The Coal
Authority

Re: 2026/44/90507/E

Discharge of details reserved by conditions 4 (bat and bird boxes), 5 (bins), 6 (Phase II Report), 7-11 (Remediation Strategy), 12 (boundaries) on previous permission 2025/91577 for erection of two semi-detached dwellings; land adjacent to 21 Westcliffe Rise, Cleckheaton, BD19 5HX

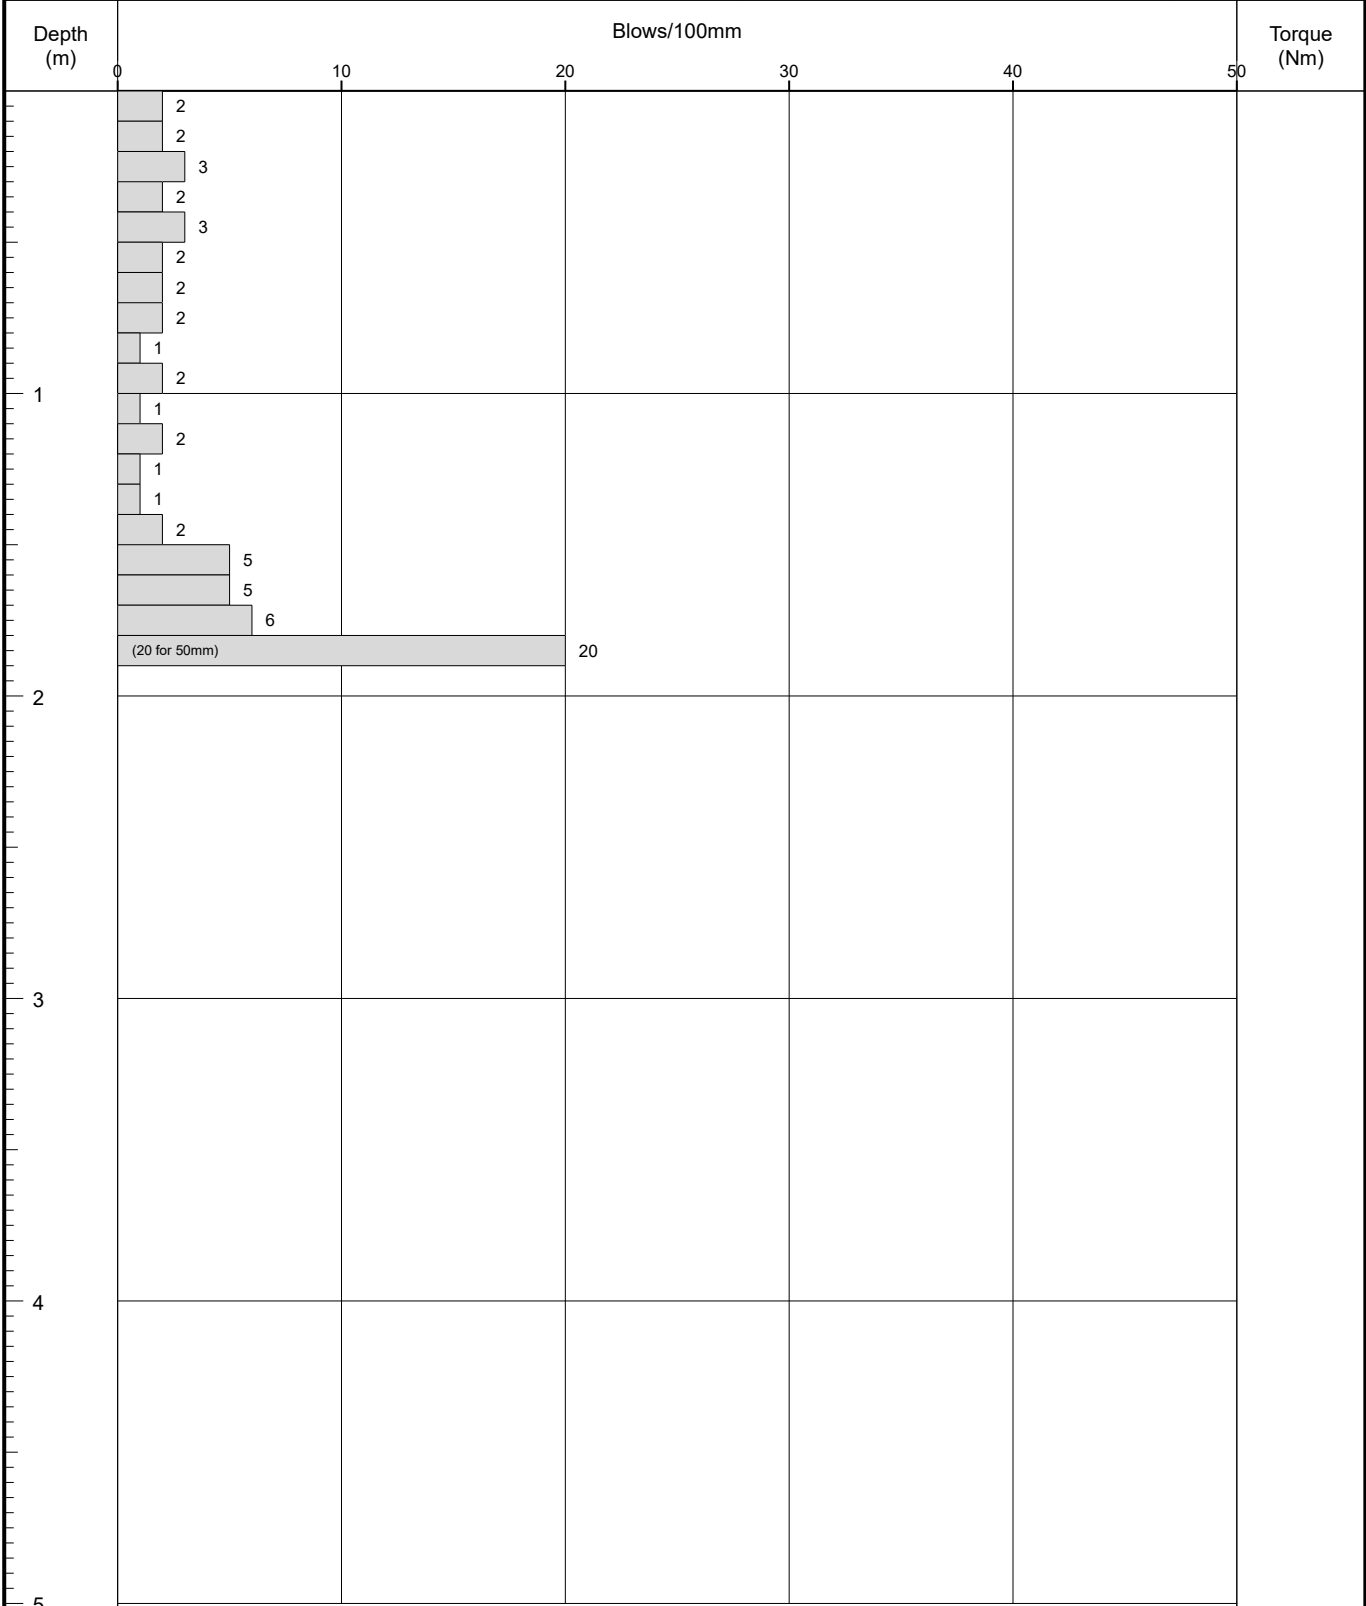
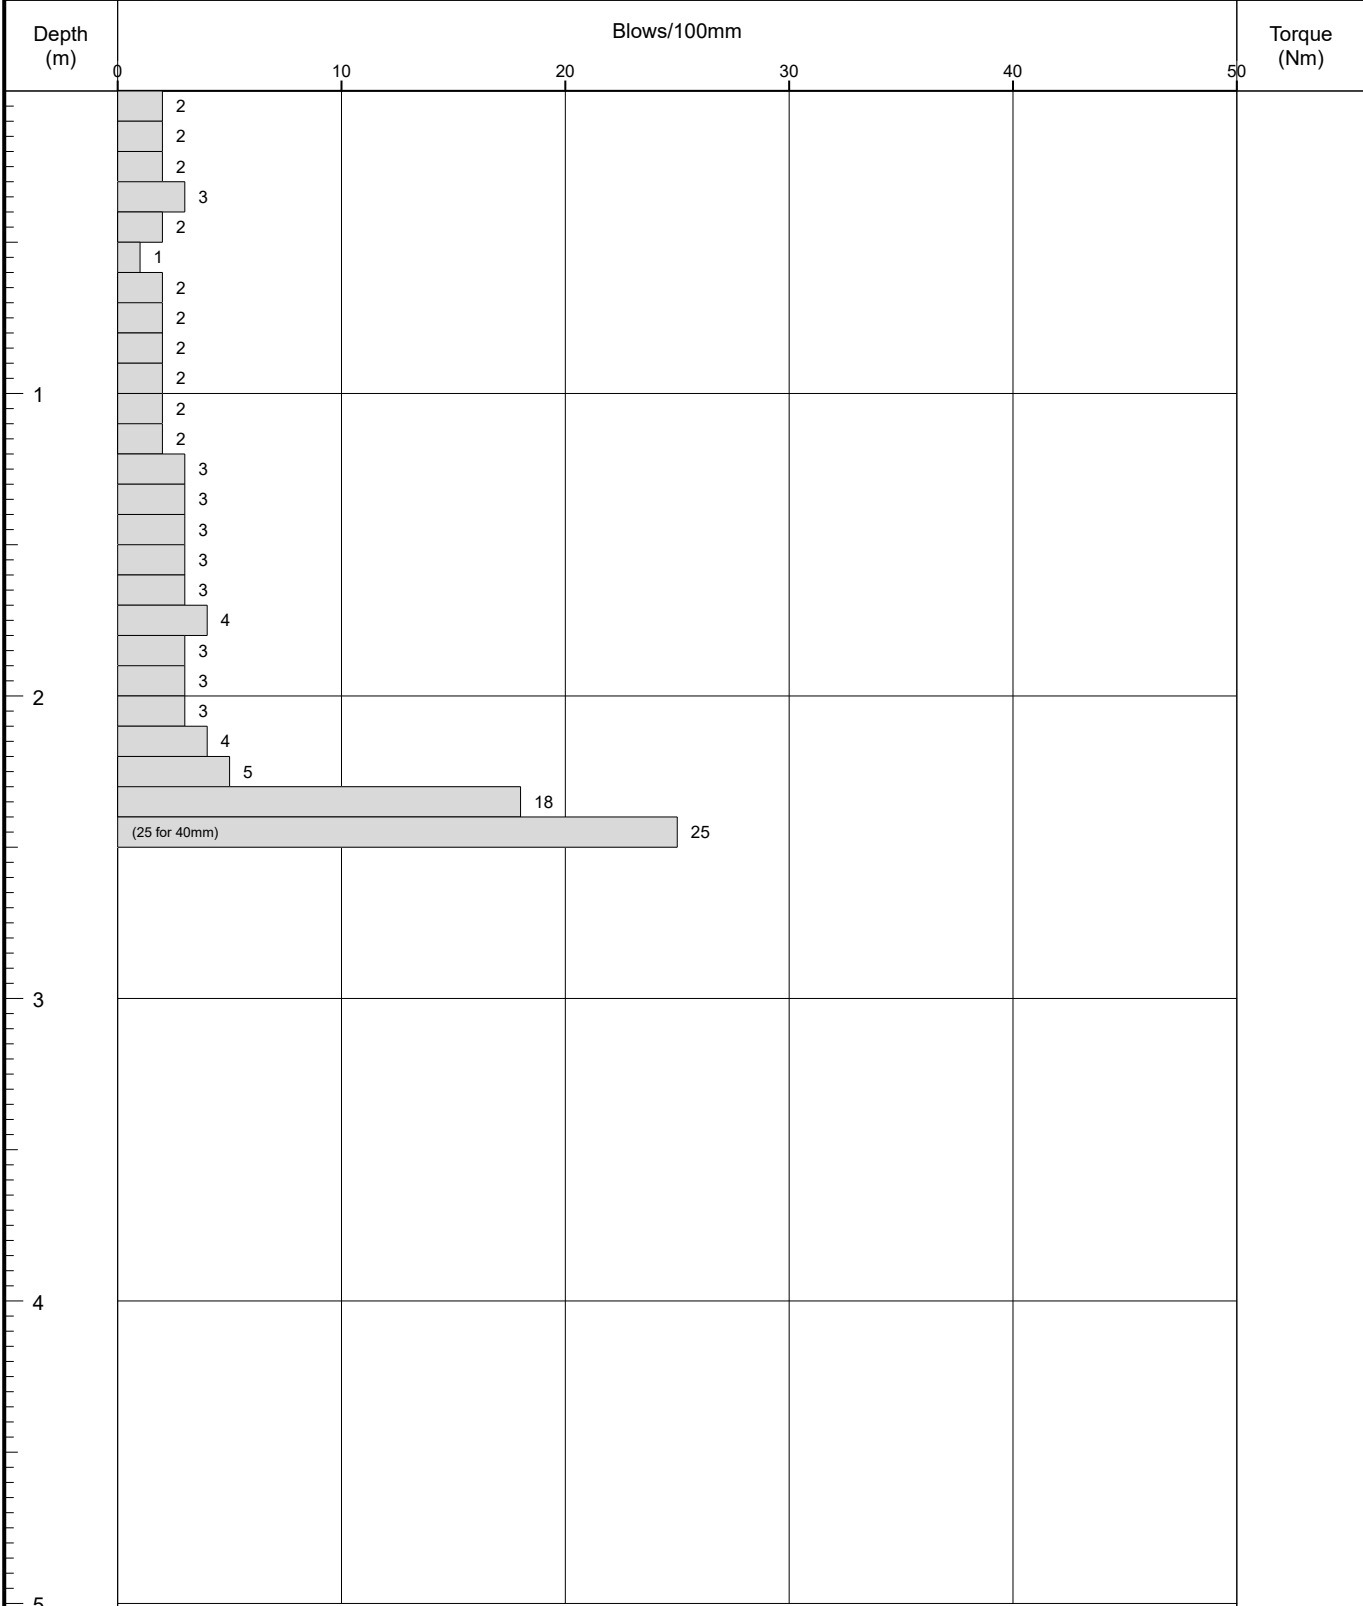
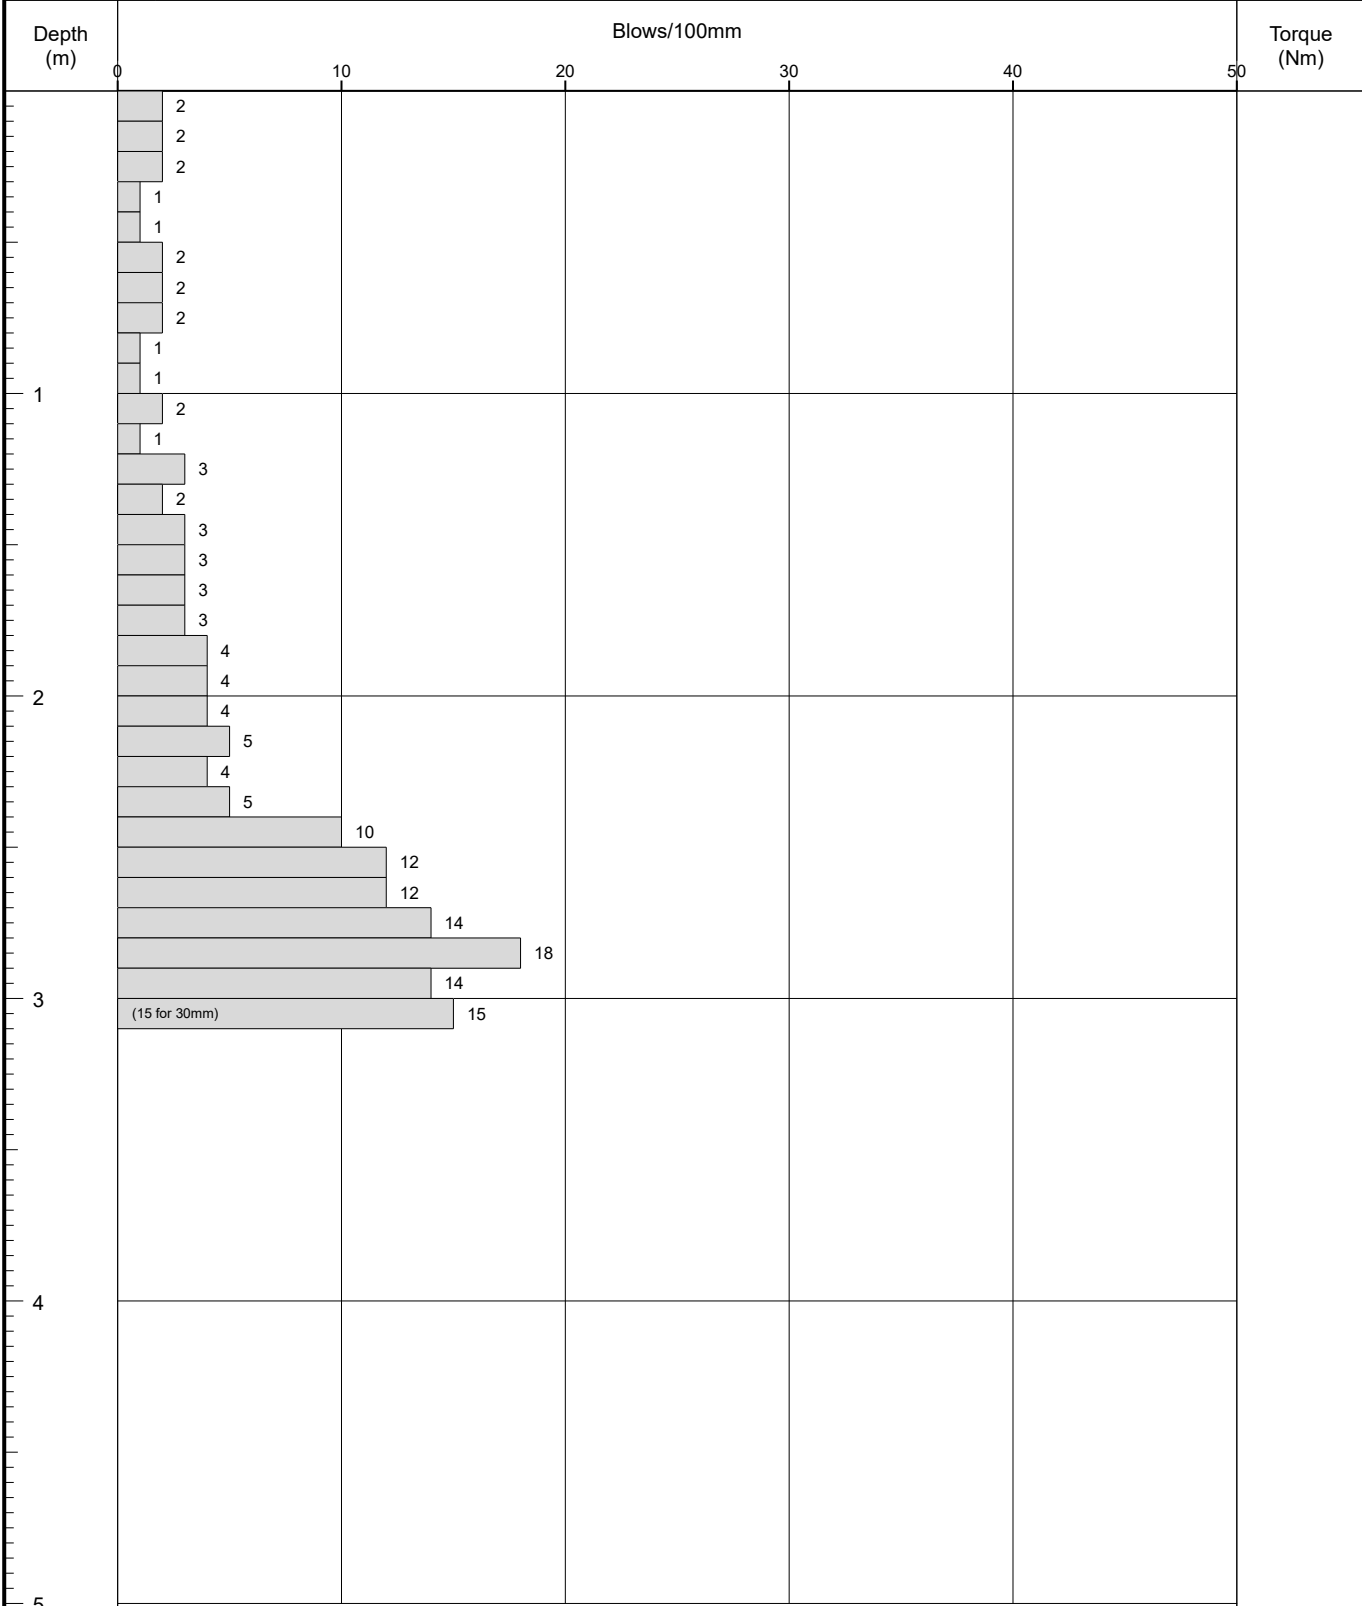
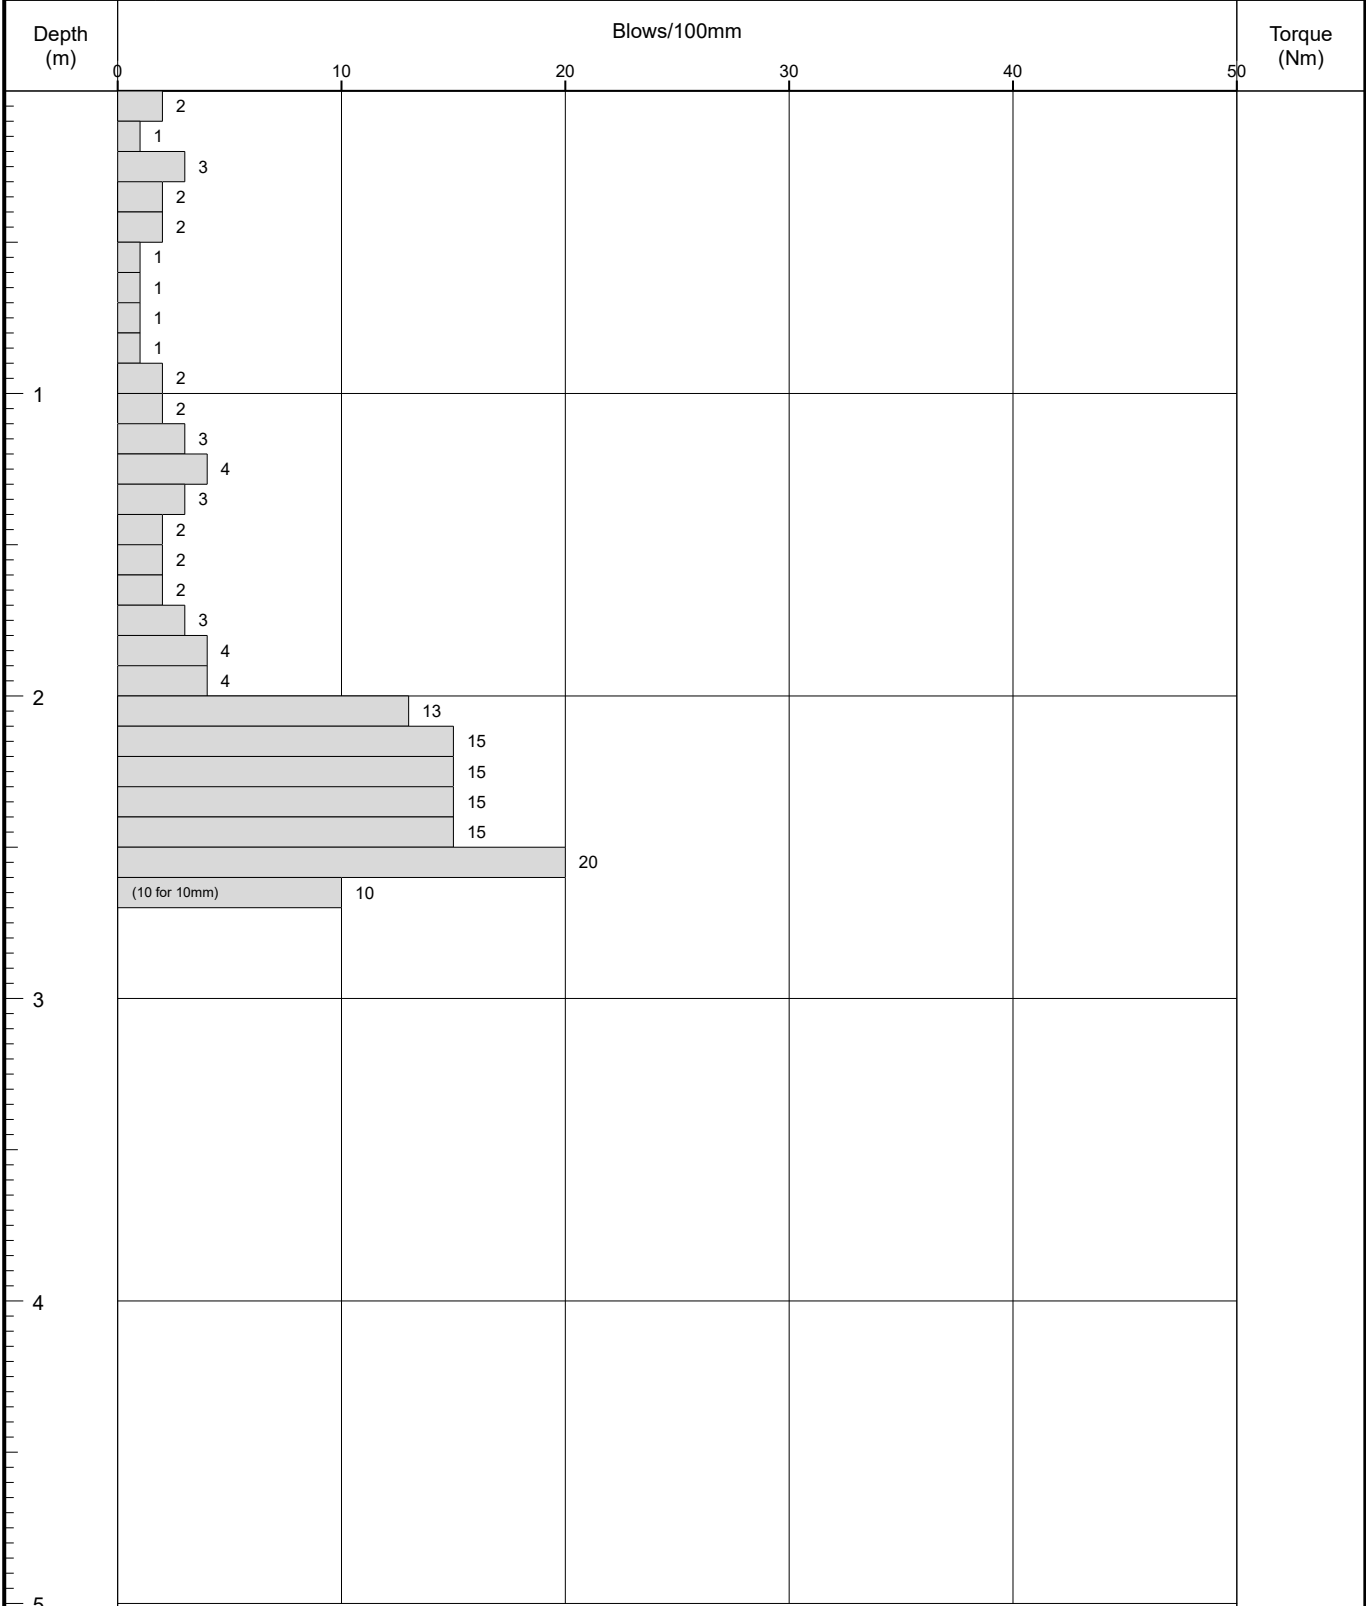
The Report is unsatisfactory as the investigations undertaken could not be considered sufficient to the extent to fully discount the risks posed by shallow coal mine workings, specifically in regard to ground stability.

The Coal Authority is therefore **unable to recommend the LPA discharge Conditions 10 and 11** and we consider that the applicant needs to revise and resubmit the Report to the LPA.
